## Jeanie Bourke - Re: Mezzanine detail

**From:** Jeanie Bourke  
**To:** Tracie Reed  
**Date:** 9/29/2015 9:08 AM  
**Subject:** Re: Mezzanine detail  
**CC:** Heather Sanborn; Nathan Sanborn

Thanks for discussing this problematic situation on the mezzanine, and revising the guard detail, in order to limit the allowable square foot floor area for storage that is accessed by an alternating tread stair. This will suffice to meet the code as opposed to redesigning the floor to achieve this maximum floor area.

MEZZANINE/FRAMING PLAN

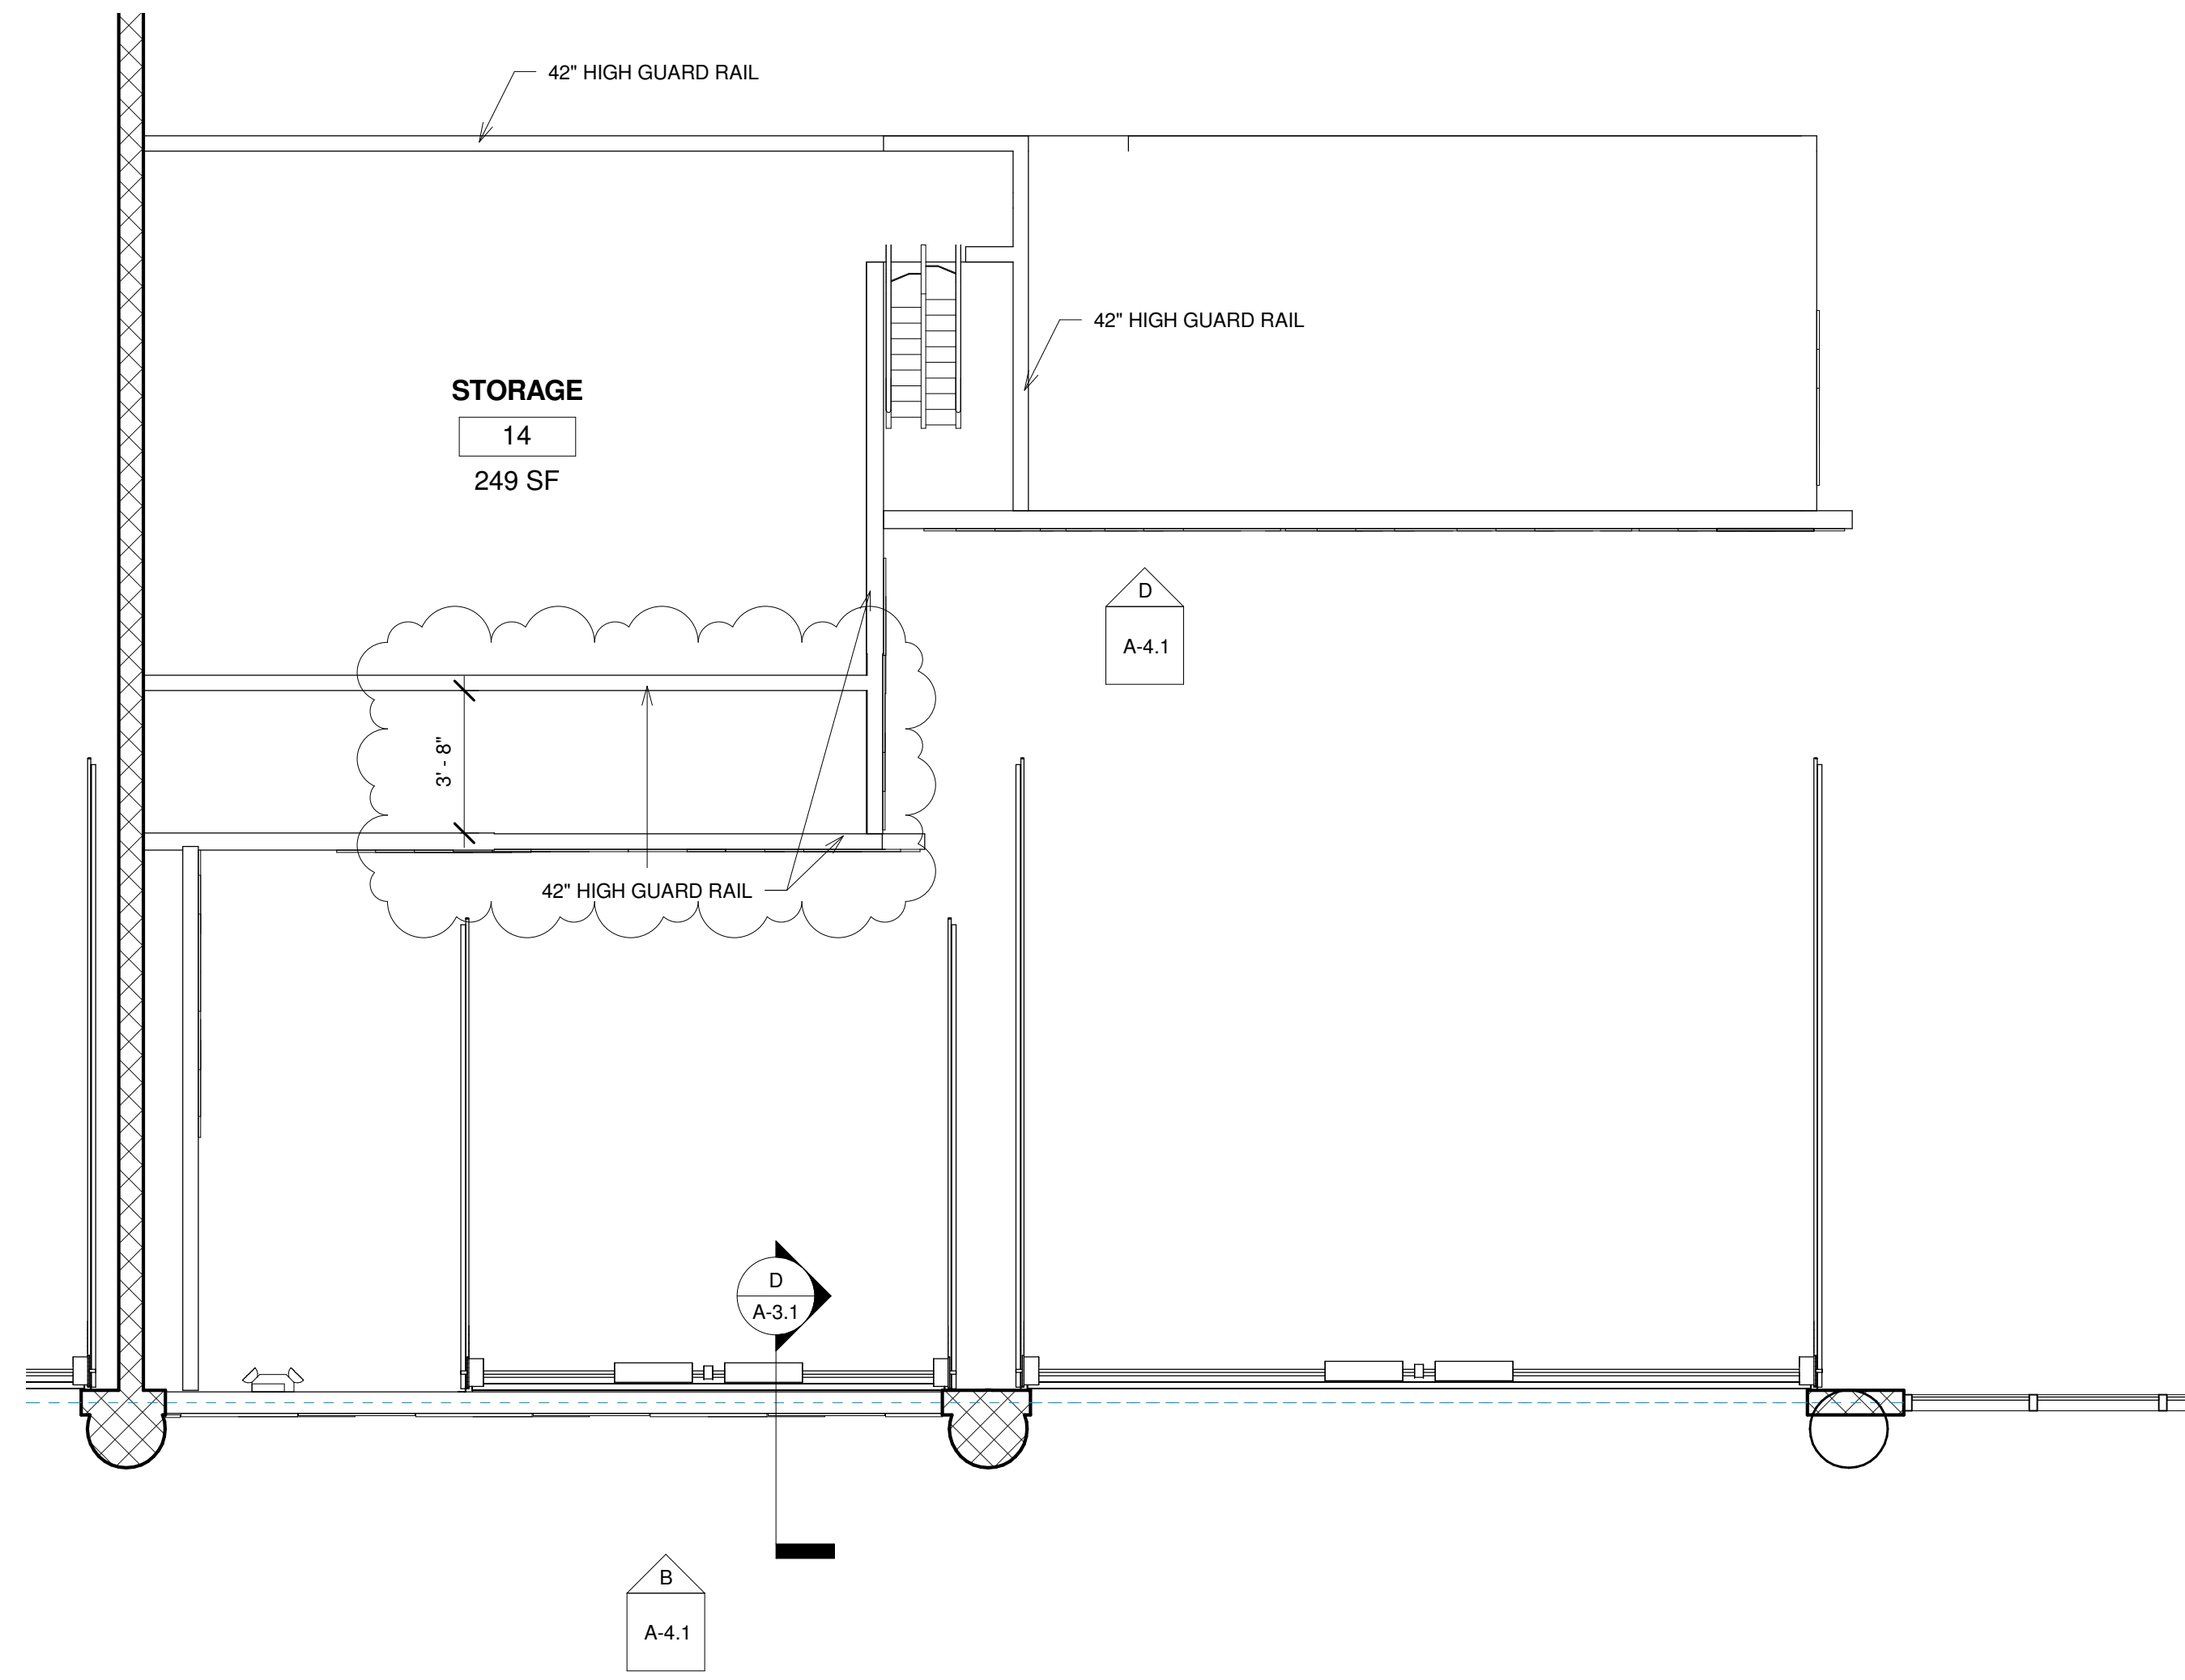
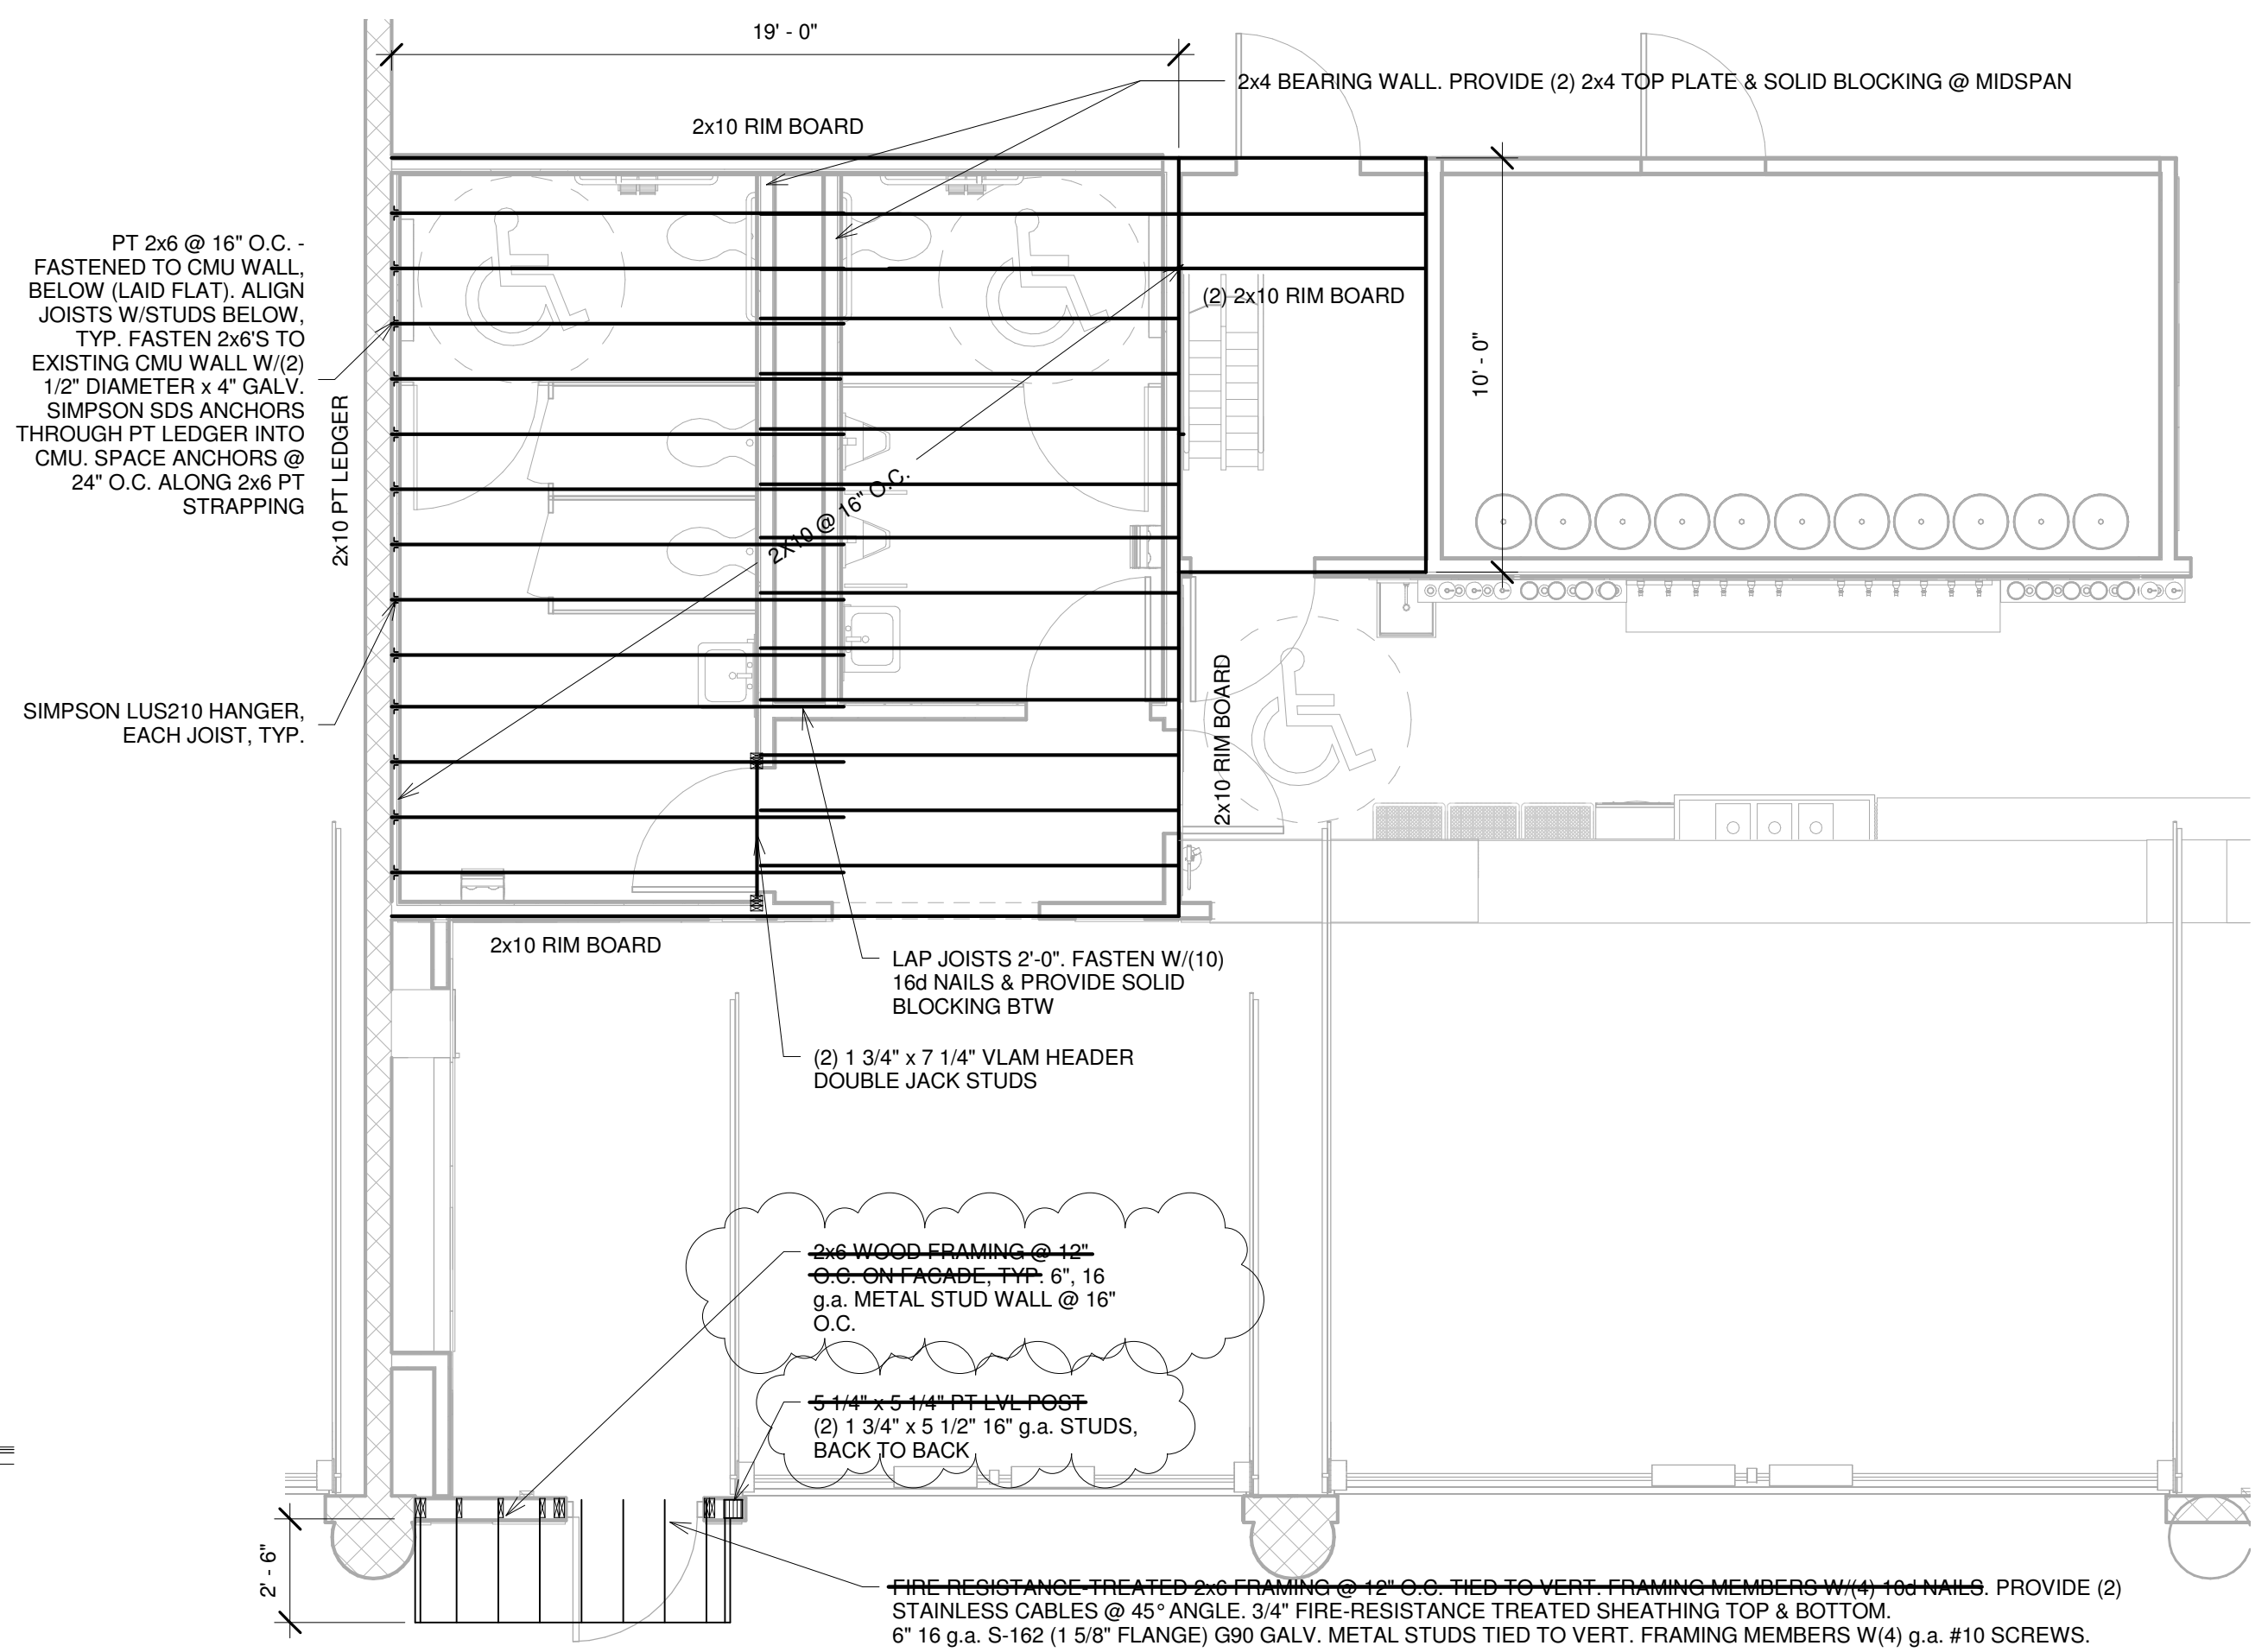
Jeanie, Thanks for the quick turnaround in terms of your comments to my revised drawings on Friday. I've attached a slightly revised detail for the mezzanine. To clarify the inner wall is 42" high with 1/2" plywood on one side. In order to make it unappealing to sit on or remove I've tied it in to the front wall every 36" with 2x4's that are set down just enough that it wouldn't be comfortable to sit atop.

I am approving the permit, it remains in review with the fire department.
